Preferred Project Report

prepared in respect of MP06_0273 (MOD 1)
for the Development of

SITE 4B

SYDNEY OLYMPIC PARK

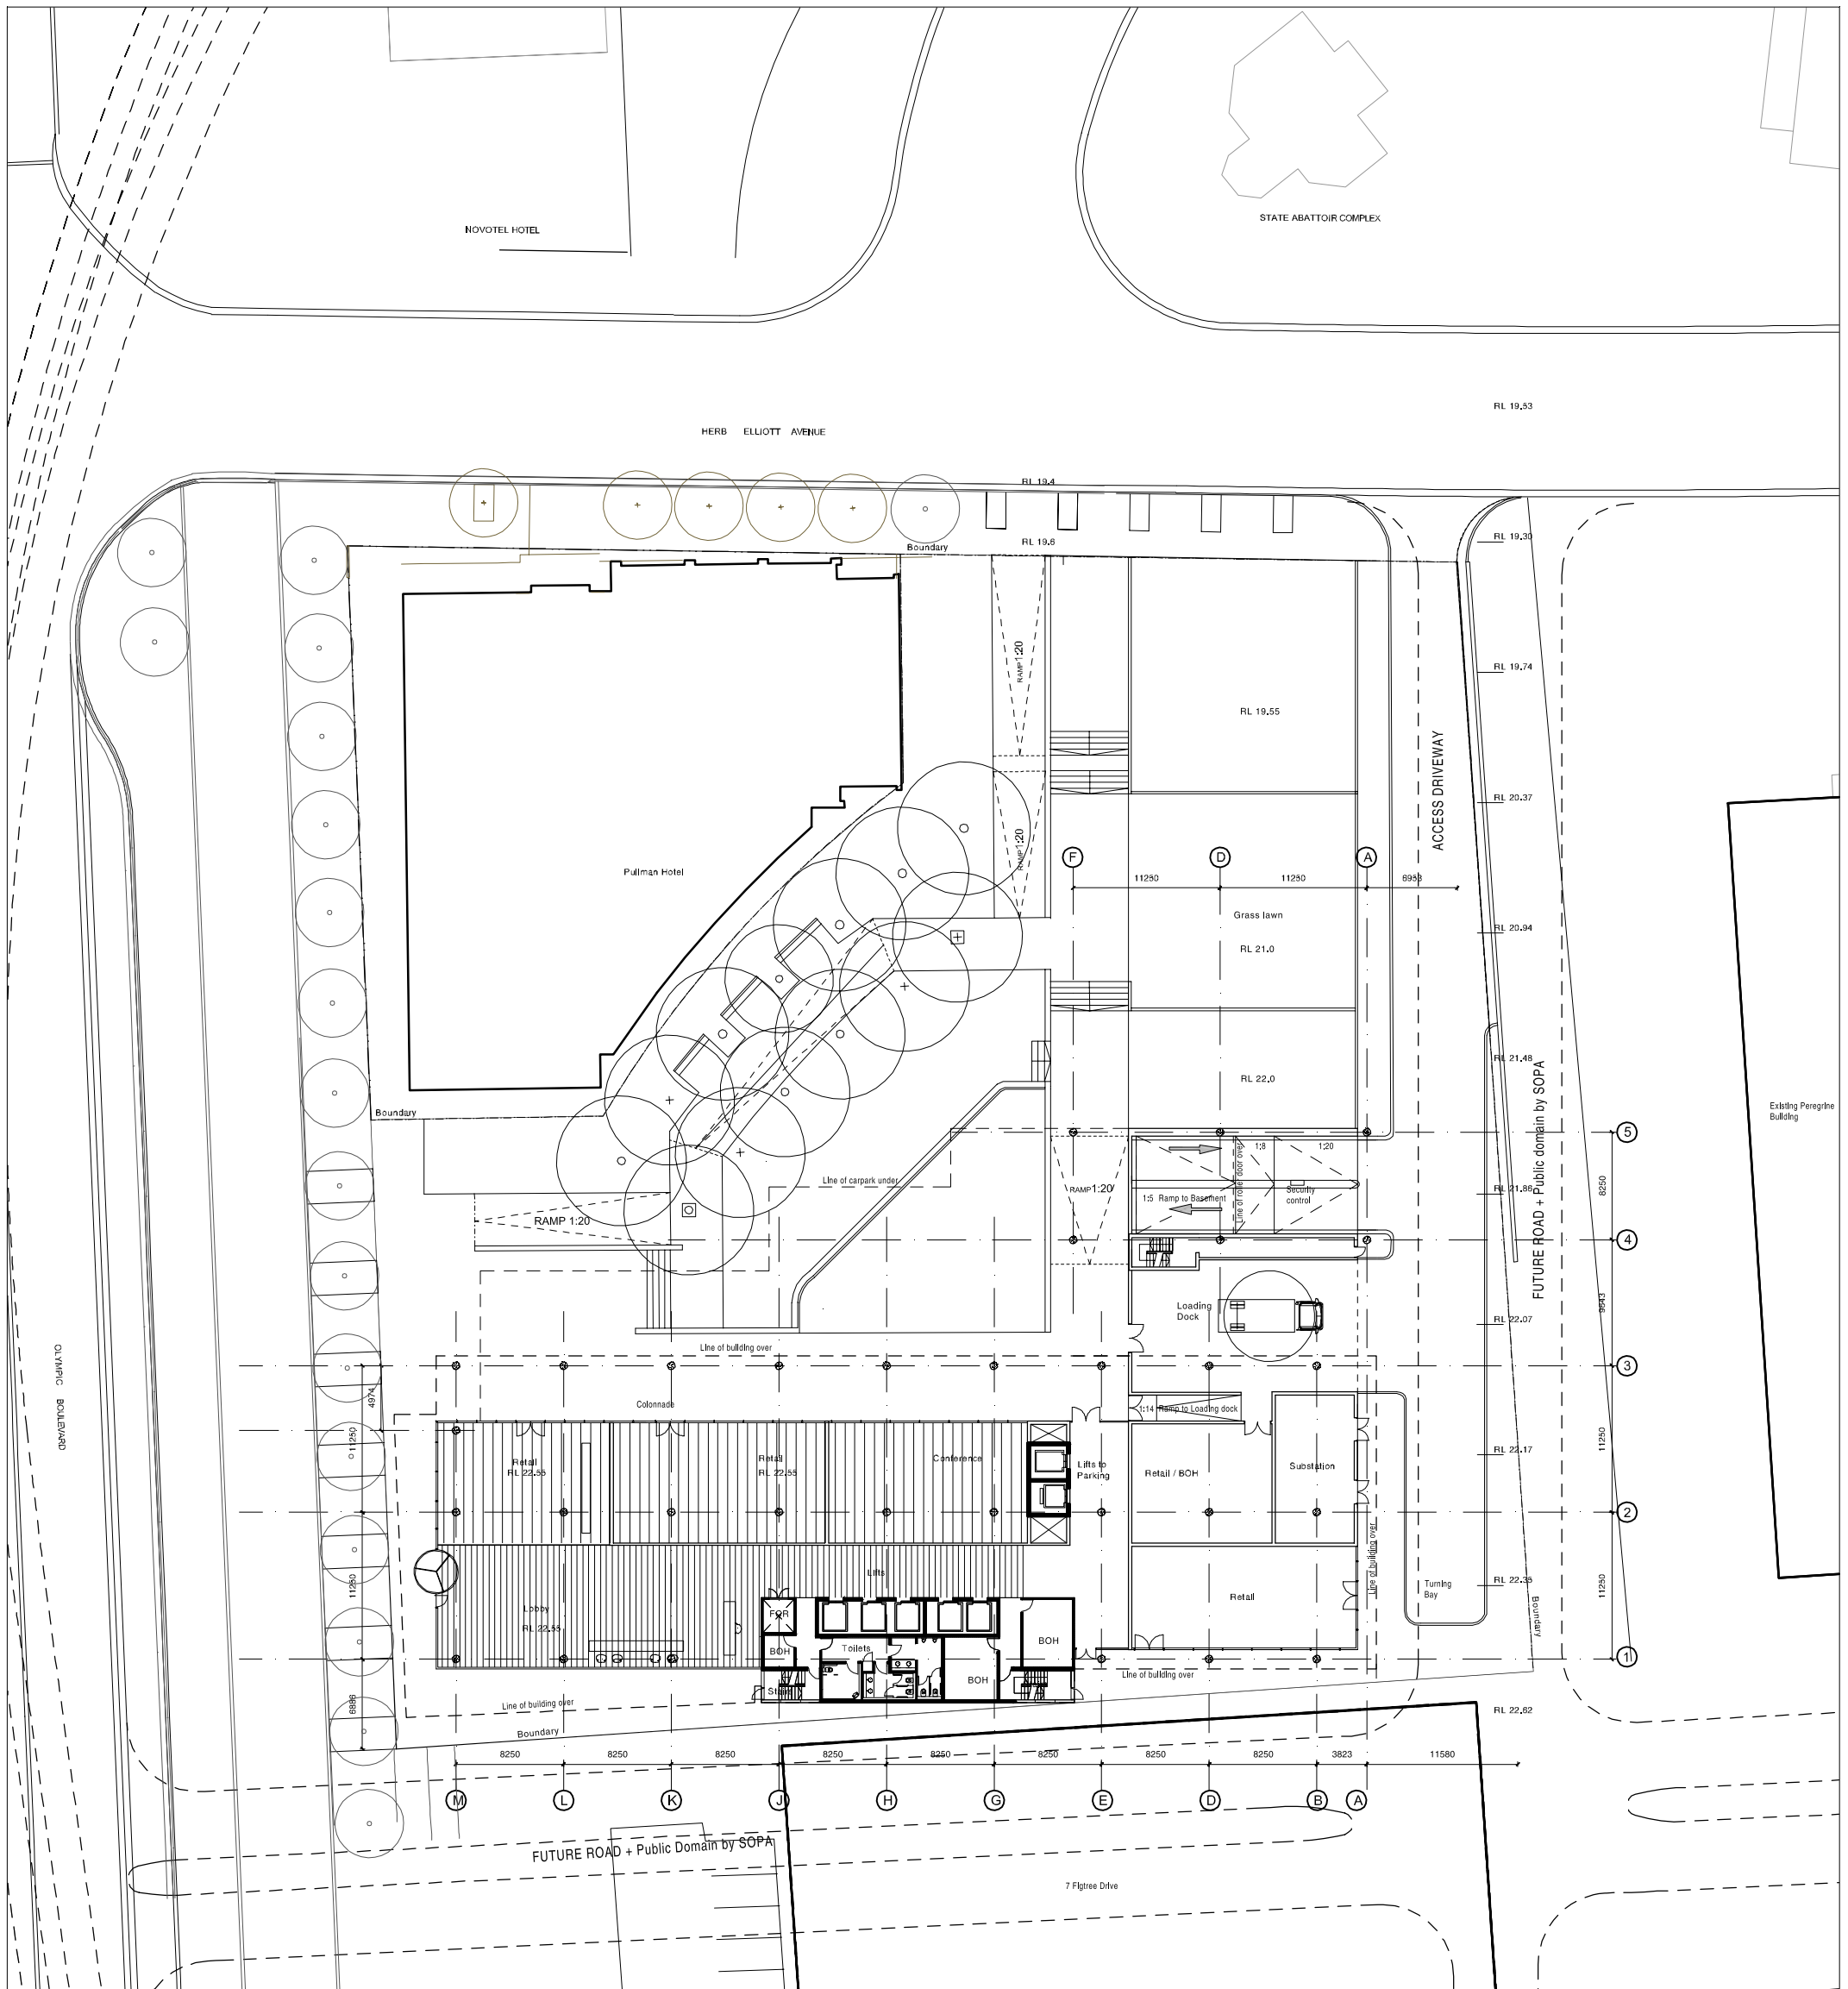
<p>Proposed Staging Appendix 2 of the documentation contains a Site Establishment Plan which shows a one way truck exit point onto Olympic Boulevard. Given that this a high-use pedestrian street and subject to road closures particularly during major events, it is considered that alternative arrangements should be conditioned accordingly.</p>	<p>Noted. The Statement of Commitments included in Section 3.0 of this report has been amended to ensure that the Construction Traffic Management Plan (Point 29) to be prepared and submitted to SOPA for approval prior to the commencement of construction includes alternative arrangements to be employed during Major Events to accommodate road closures and increased pedestrian activity.</p>

Figure 13: Eastern Elevation

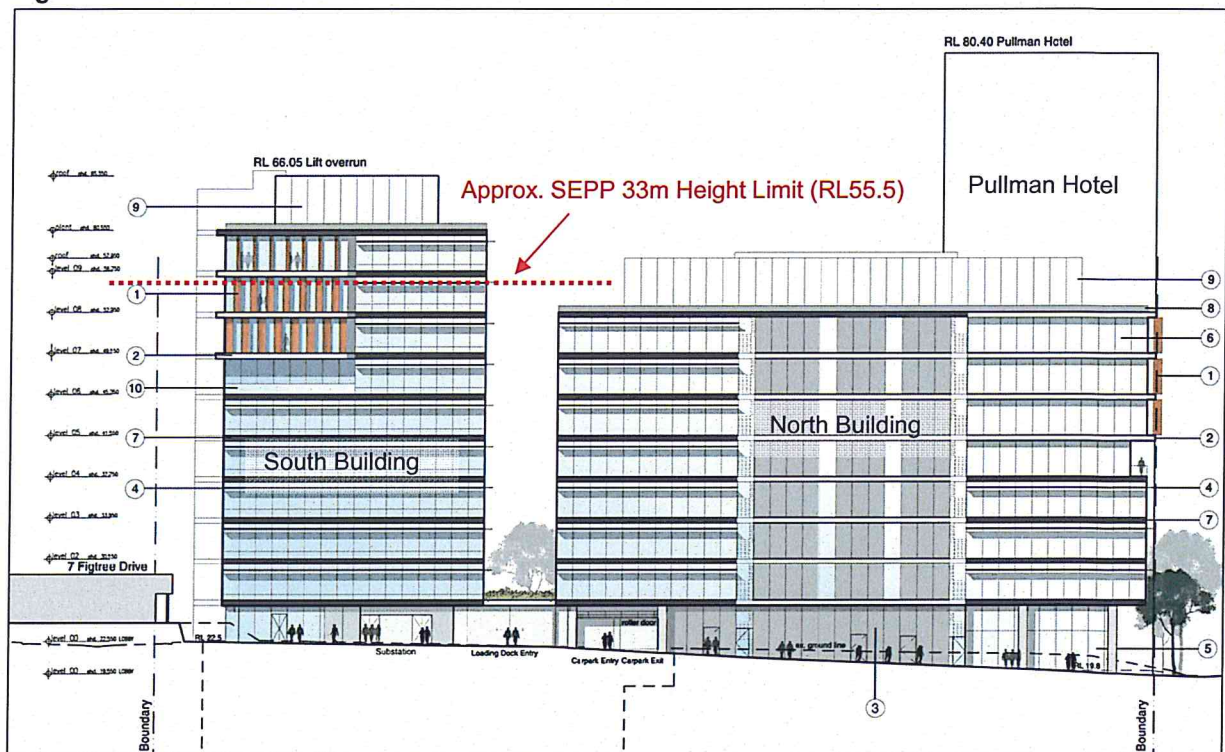
Roads and Traffic Authority submission of 28 February 2011	
No objection to the proposed modification.	Noted.
Sydney Olympic Park Authority submission of 7 February 2011	
<p>Height of South Building The South Building at its eastern end exceeds the 33m height limit by approximately 2 storeys. The documentation provided does not address this aspect of the modification. The proponent should provide justification for the additional height taking into consideration clause 21 of the SEPP (Major Development) 2005.</p>	<p>Clause 21 of Schedule 3 of the Major Projects SEPP provides that:</p> <p><i>A development standard imposed by this or any other environmental planning instrument on development that is part of a project to which Part 3A of the Act applies, and is within the Sydney Olympic Park site, does not apply to that development if the Director-General is satisfied, and issues a certificate to the effect, that:</i></p> <p>(a) <i>compliance with the development standard is unreasonable or unnecessary in the circumstances of the case, and</i> (b) <i>there are sufficient environmental planning grounds to justify exempting the development from that development standard.</i></p> <p><i>In deciding whether to issue a certificate, the Director-General must consider:</i></p> <p>(a) <i>whether contravention of the development standard raises any matter of significance for State or regional environmental planning, and</i> (b) <i>the public benefit of maintaining the development standard, and</i> (c) <i>any other matters required to be taken into consideration by the Director-General.</i></p> <p>The Sydney Olympic Park Master Plan 2030 (Figure 5.8 – Central Precinct Building Heights) illustrates the height of development on the site and provides for a 50m deep “tower zone” along the Olympic Boulevard frontage of 20 – 30 storeys. The eastern portion of the site is restricted to 8 storeys.</p>

Issue	Response
	<p>The Southern Building addresses Olympic Boulevard and achieves a height of 10 storeys (well below the maximum height of 20 – 32 storeys permitted under the Master Plan) however the eastern end of the building (for a distance of approx. 24 metres or 32% of the length of the building encroaches into the 8 storey height zone.</p> <p>The height standard is part of a suite of built form controls which are designed to control the siting, bulk and scale and density of development.</p> <p>Section 4.6.4 of the Master Plan sets out the objective of the Height Control as follows:</p> <p><i>To reinforce the primacy of Olympic Boulevard and the town and create consistent building heights along main streets, maintain solar access to the public domain and maintain the iconic Olympic skyline.</i></p> <p>Subclause 2 enables minor increases to the heights nominated in the Building Heights Plans to be considered in the following circumstances:</p> <ul style="list-style-type: none"> • special site conditions make strict compliance with the controls unworkable • there are demonstrable improvements to urban form and height transition • resident amenity in terms of privacy and solar access is not adversely affected • there is no impact on public open space and parklands. <p>Having regard to the above, the minor non-compliance with the height control over a portion of the development site is considered to be reasonable in this instance because:</p> <ul style="list-style-type: none"> • the site is awkwardly configured and is constrained by the requirement to preserve the through-site link whilst achieving large, regular floor plates with optimal solar access; • the additional two storeys at the south eastern corner of the site serve to reinforce this corner, resulting in a built form which provides an appropriate transition to future development to the east (which is separated by the future road); and • the proposed non-compliance does not manifest itself in any substantive impacts in terms of overshadowing to the proposed area of open space to the south east (refer Shadow Diagrams at Appendix 2) or loss of privacy / solar access to residential properties. In relation to privacy, it is noted that the nearest site designated for future residential development in the Sydney Olympic Park Master Plan 2030 is located some 100 metres to the south east on Figtree Drive (refer Figure 5.7 Central Precinct Land Use Plan). <p>As the Department is aware, the proposal (as amended) is within the maximum permissible FSR of 6.5:1 (achieving an FSR of 6.48:1), which is required to be achieved in order to make the project economically viable. Strict compliance with the height control would require the</p>

Issue	Response
	<p>redistribution of this GFA and could potentially result in either a less elegant architectural solution, a poor urban form or could compromise the quantum of outdoor / public spaces around the base of the buildings.</p> <p>On this basis, it is considered that notwithstanding the breach of the height control, the proposed development results in a better urban form design outcome.</p>
<p>Building Design The loading dock and car park access has been combined in the modification. Consideration should be given to the provision of shutters or folding doors to improve the appearance of this combined entrance to the public domain.</p>	<p>The loading dock and car park access are immediately adjacent but are physically separated by a wall (refer Drawing Nos. A07.002 for the elevation and A3.000 for the plan of this area).</p> <p>Roller shutter doors will be provided to these vehicular access points. It should be noted that these doors are shown on the drawings which accompanied the S75W application.</p>
